**CHARLOTTE FIRE DEPARTMENT**  
**700 North Tryon Street**  
**Post Office Box 31097 Charlotte, N.C. 28231-1097**

**Plan Review Sheet**

**Petitioner: Novant Health, INC**  
**Petition Number: 2008-052**  
**Fire Plans Examiner: R. Turner**  
**Telephone: 704-336-3814**

**Review: 1**  
**Date Received: 2-11-08**  
**Date Reviewed: 3-6-08**  
**Fax: 704-336-3839**

**Site Plan**

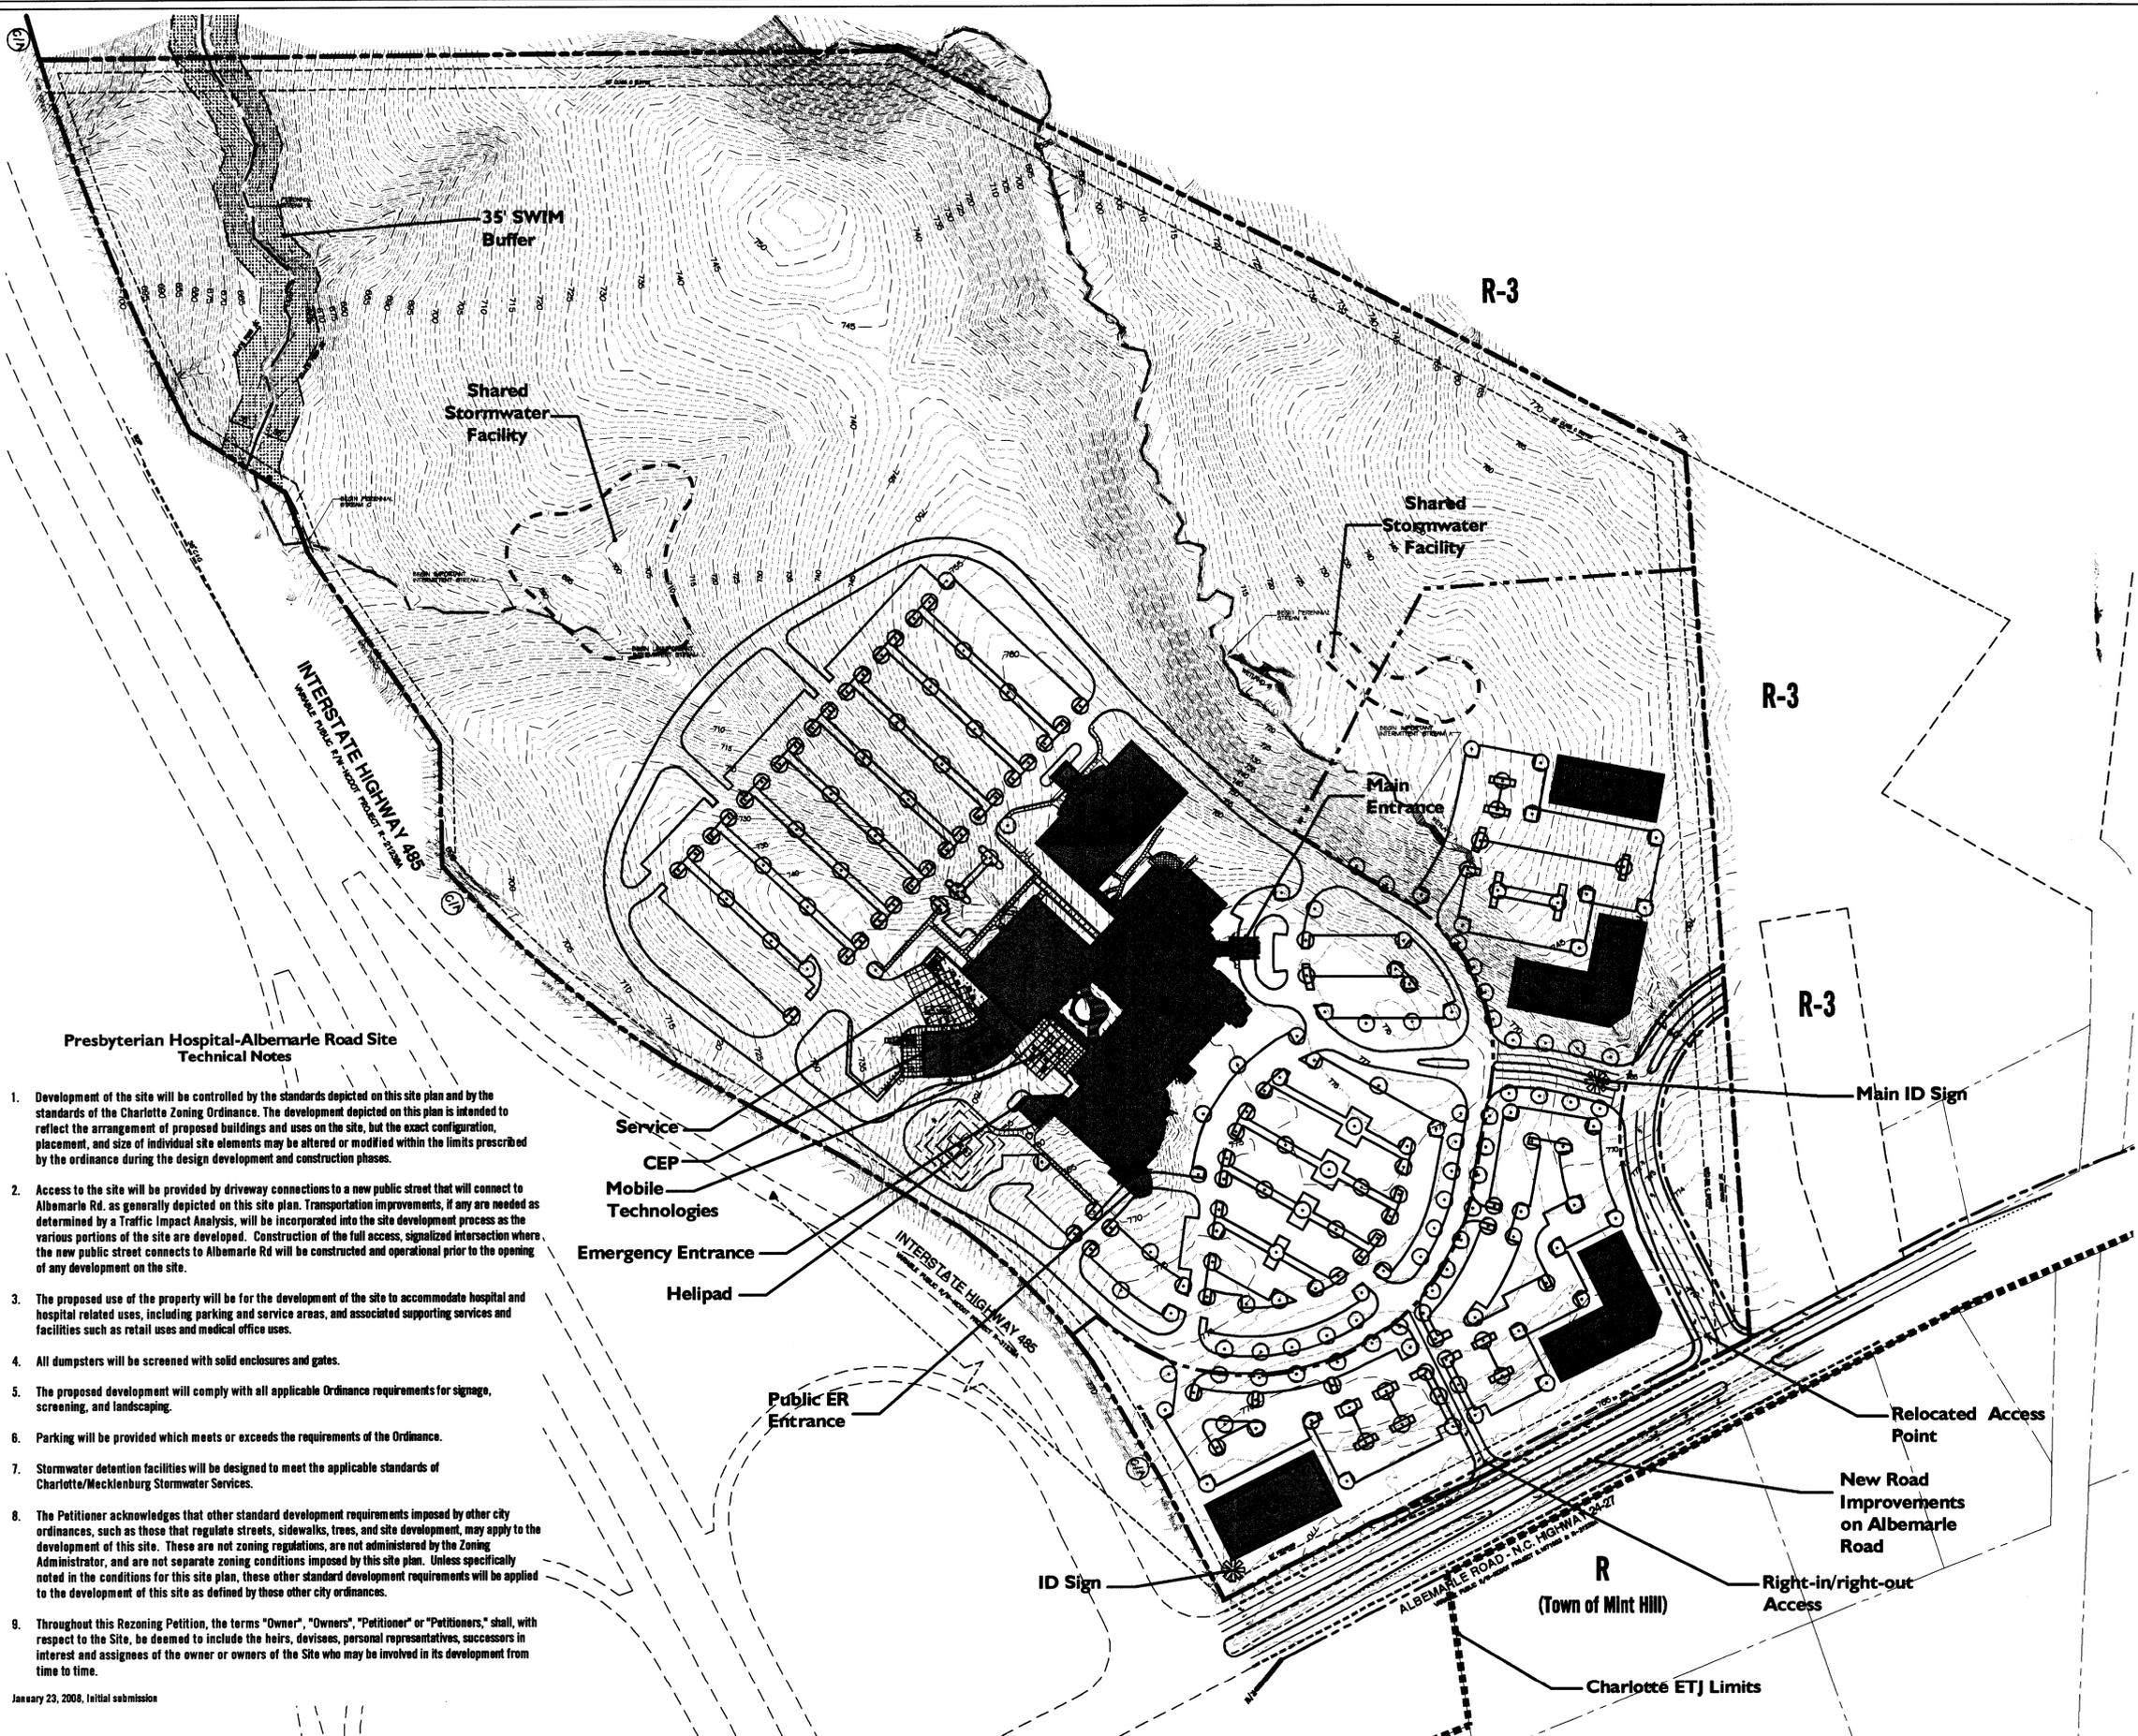
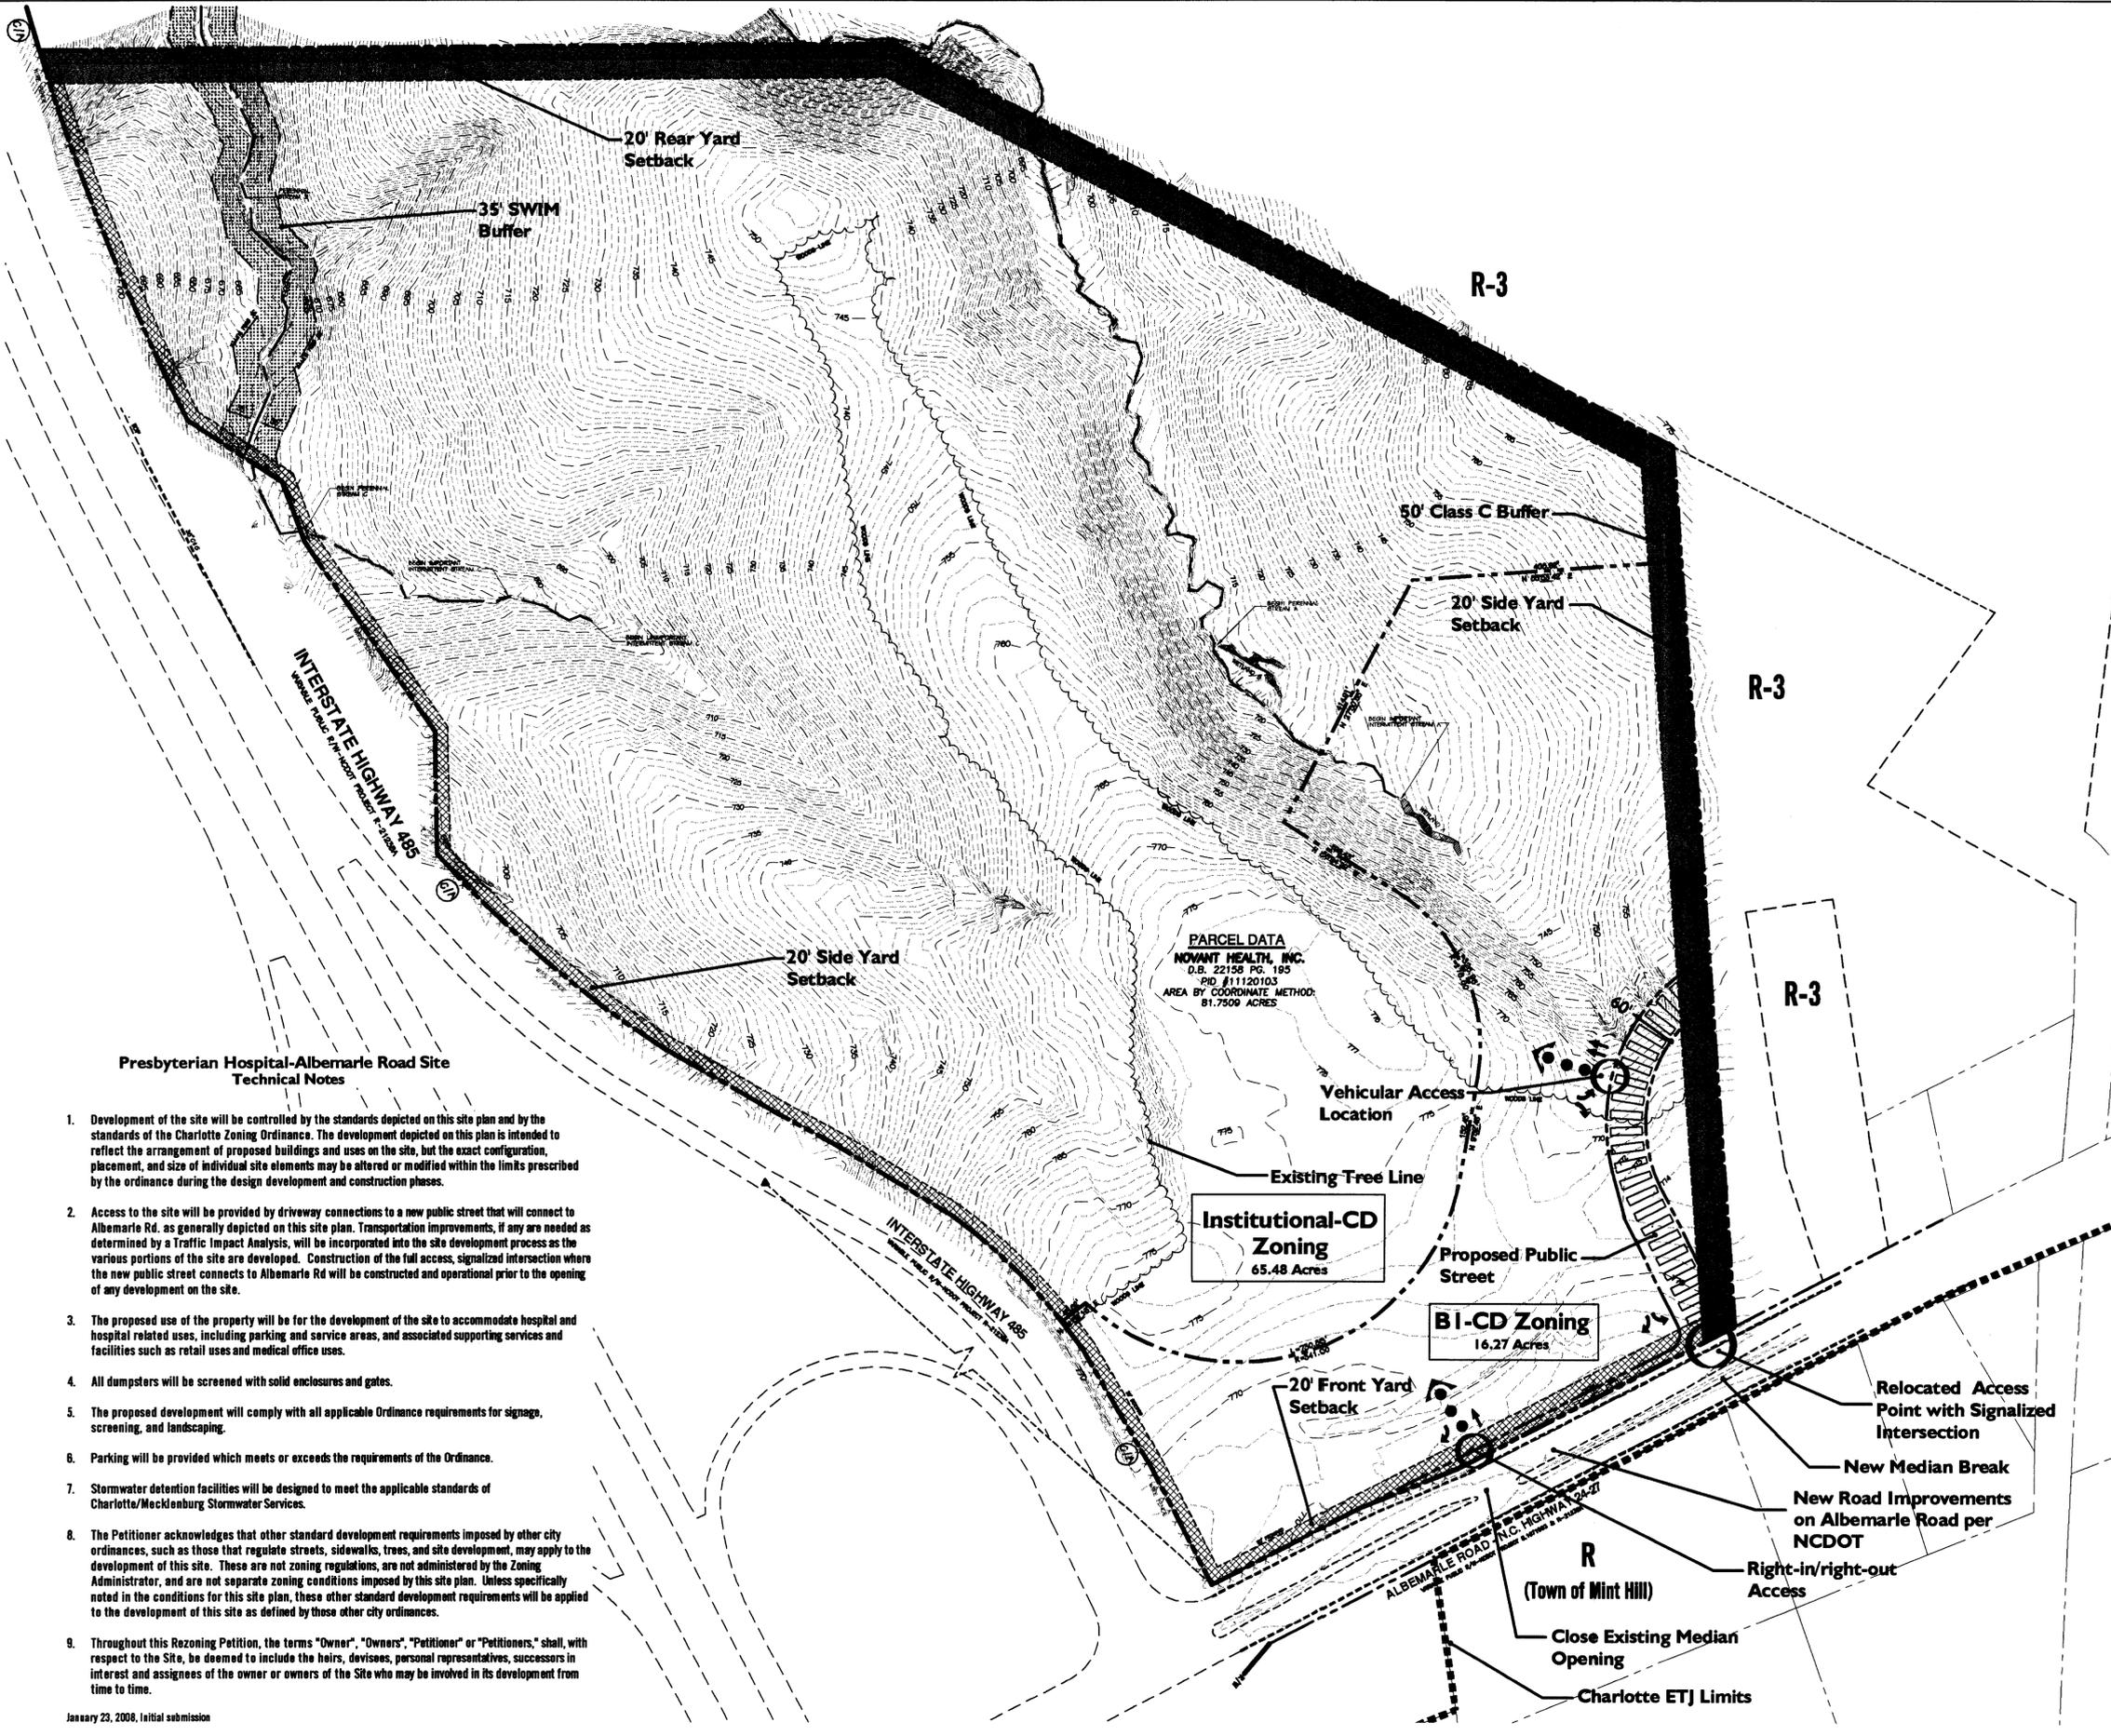
**It has come to our attention, that due to the location of our existing fire station (23) and to the location of our new fire station (40), a response and access problem exists for this proposed location. Since the existing roads infrastructure will not allow an acceptable response time, especially for a complex of this nature and magnitude, it is suggested that possible solutions be examined before this petition is approved.**
